# Appeal Decision

**Appeal Ref: APP/R5510/D/22/3305837**

**51 Royal Lane, Hillingdon, Uxbridge UB8 3QU**

- The appeal is made under section 78 of the Town and Country Planning Act 1990 against a refusal to grant planning permission.
- The appeal is made by Mr D Singh against the decision of the Council of the London Borough of Hillingdon.
- The application Ref 77348/APP/2022/1840, dated 7 June 2022, was refused by notice dated 2 August 2022.
- The development proposed is ground floor rear extension.

PROPOSED GF LAYOUT

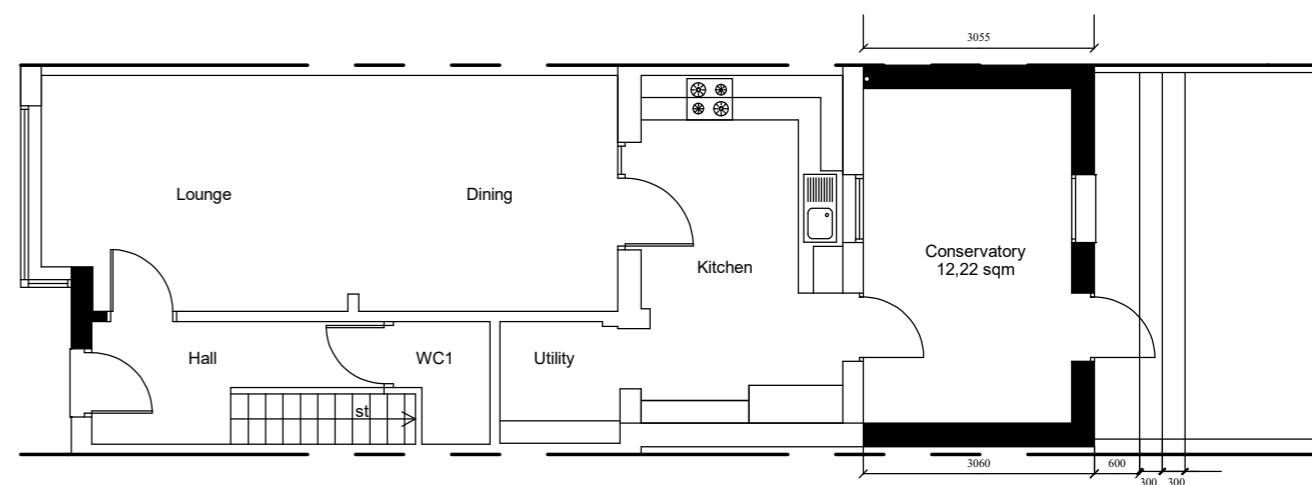
7. Whilst it would increase the footprint of the dwelling to its rear, the extension would be set down from the existing extension, meaning it would have a subordinate appearance when viewed against the rear elevation. Further, the lengthy garden would allow the additional footprint to be comfortably accommodated within the plot and a well sized garden would be retained. A condition is suggested to incorporate matching materials and this could be included.

PROPOSED REAR & SIDE ELEVATIONS  
Scale 1:100

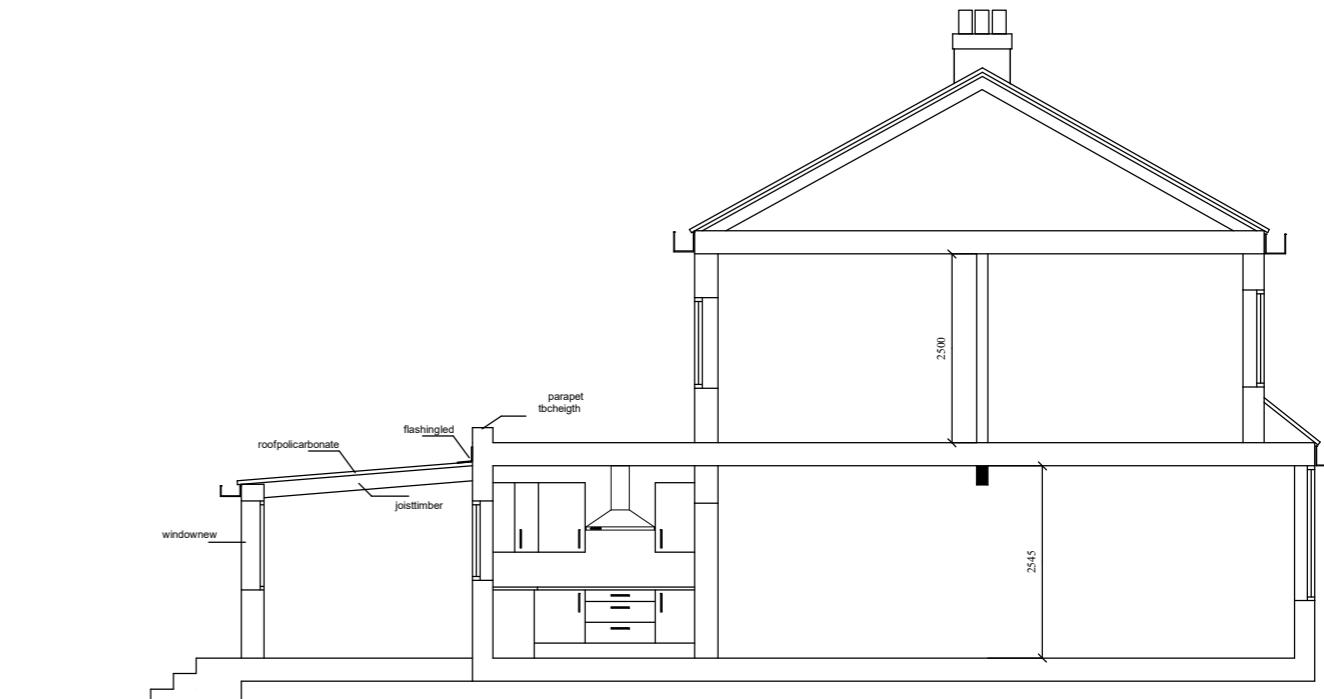
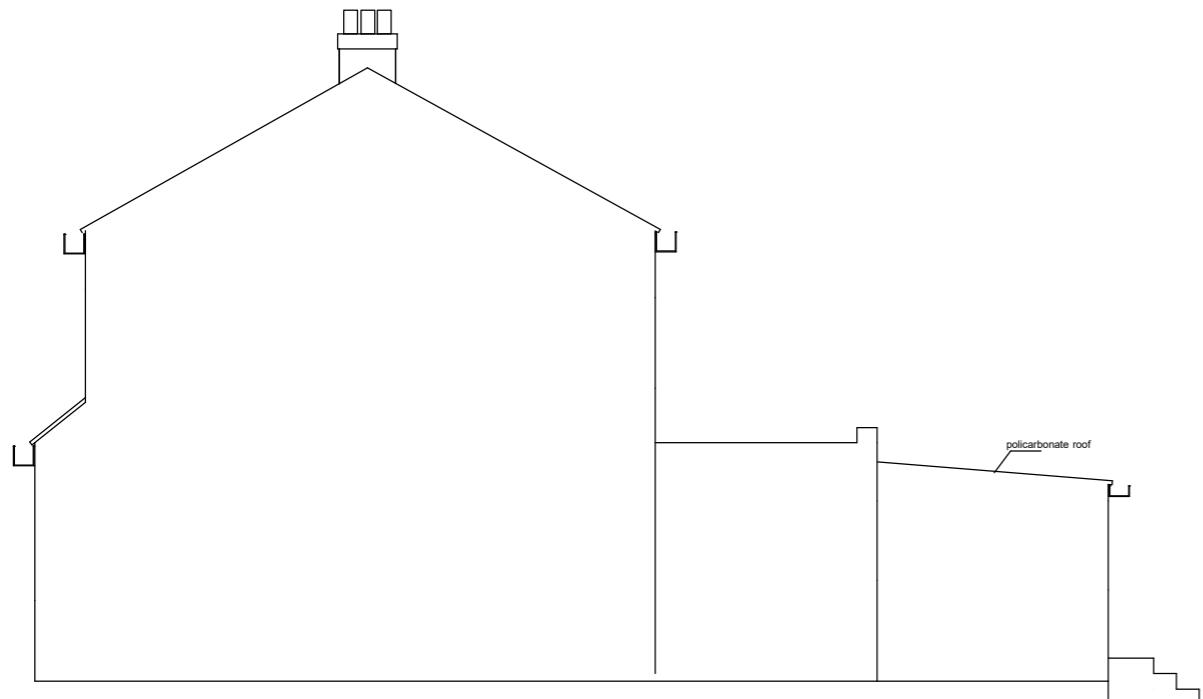
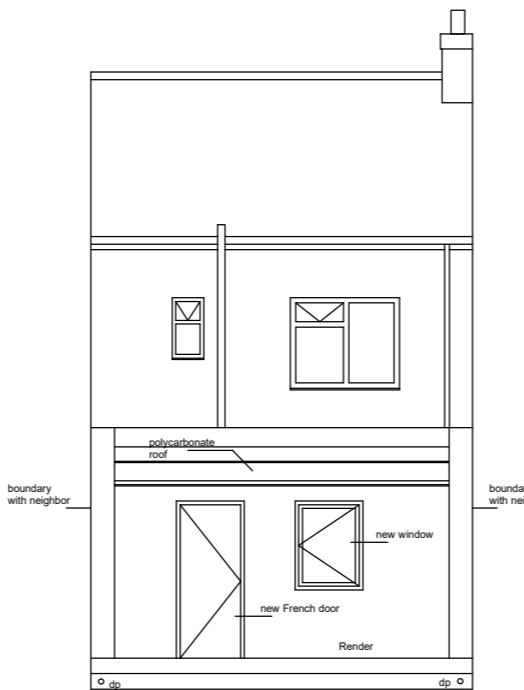
10. The extension would have blank side elevations. Whilst I acknowledge that the steps and platform access would be raised which would allow views into the neighbouring gardens at No.49 and No.53, these views would only be brief given the shallow nature of the top level of the steps which would not offer an area of the size on which residents would be likely to spend any length of time.
11. There would therefore be no significant adverse impact with regard to the living conditions of the occupiers of both No.49 and No. 53 with particular regard to overlooking and privacy.
12. The extension would form an obvious feature to the occupiers of No.53 which has not in itself been extended. However, the main ground floor windows on

the rear elevation are located on the north-eastern side of the property and in views from these windows the effect of the extension would be more limited.

13. Further, I am mindful that the extension would be of single storey design with a shallow pitched roof of limited upward projection. It is also the case that No.53 has a garden of good length and much of the garden would be well away from the extension.
